**re: Grading Plan Review**  
Proposed Residential Development  
2506 Innes Road – Ottawa, Ontario  
**to:** Concorde Properties – **Jordan Tannis** – [jt@concorde-properties.ca](mailto:jt@concorde-properties.ca)  
**date:** May 1, 2024  
**file:** PG6818-MEMO.02

## **Grading Plan Review**

- Grading Plan – 2506 Innes Road – Job No. 23087 – Drawing No. C4 – Revision 3 dated May 1, 2024.

Drawing Title
GRADING PLAN

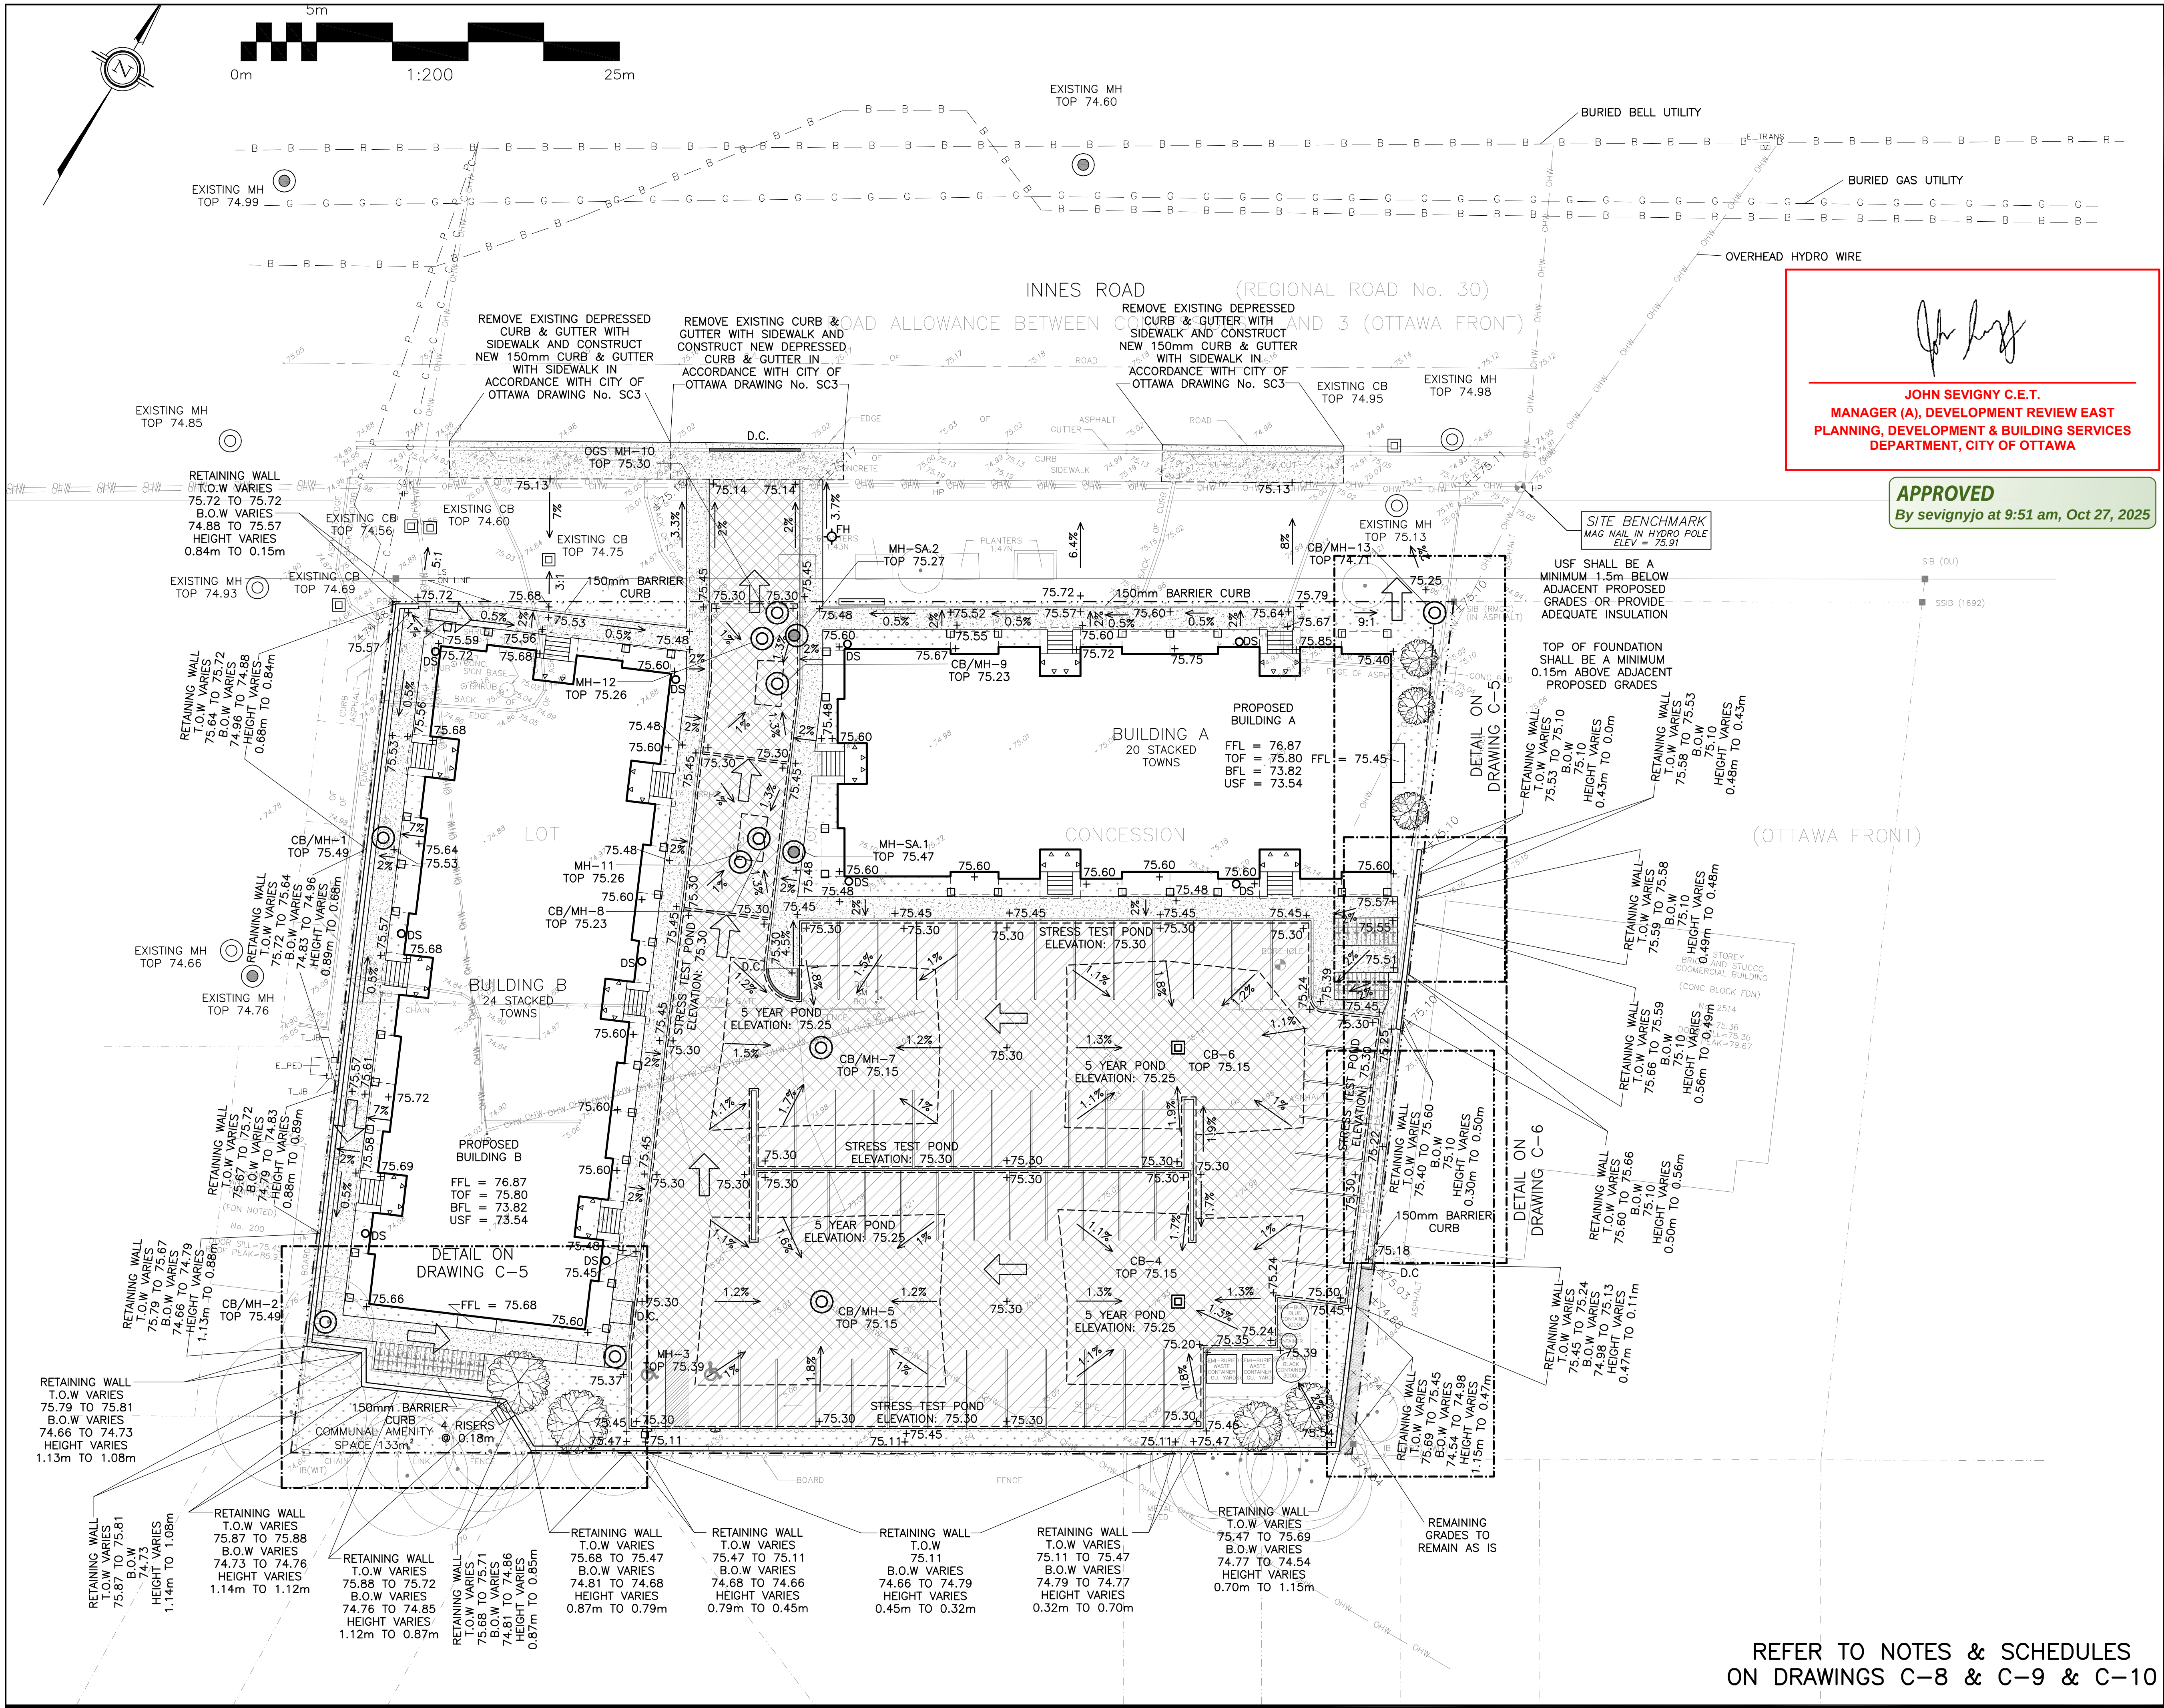
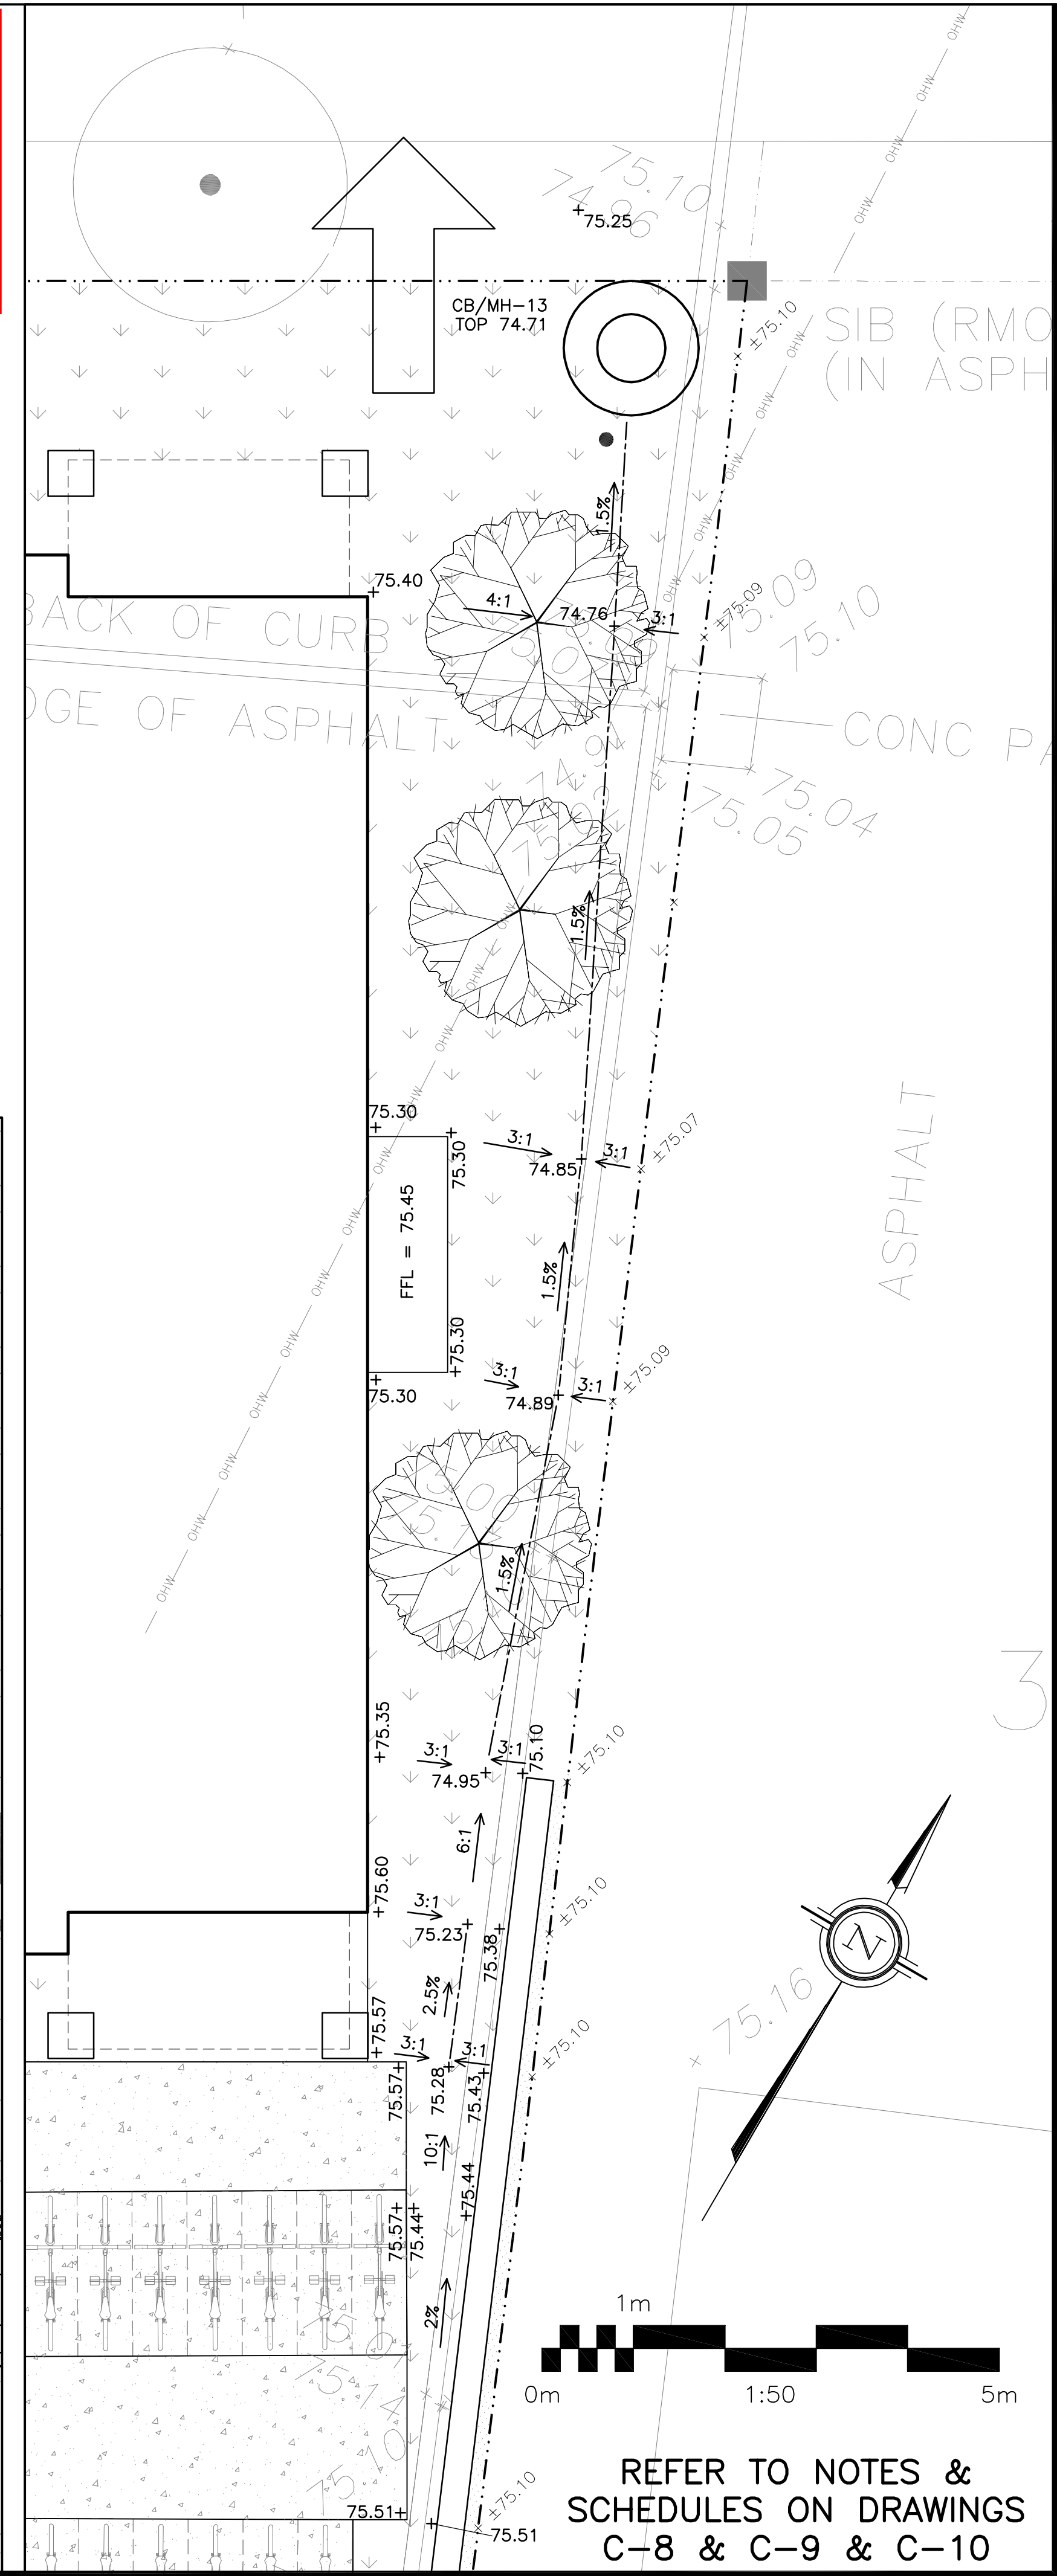
Due to the presence of a silty clay deposit underlying the subject site, a permissible grade raise restriction of 1.5 m was recommended for grading at the subject site. Based on our review of the grading plan, no grade raise exceedances were noted, as such, the proposed grading is considered to be acceptable from a geotechnical perspective.
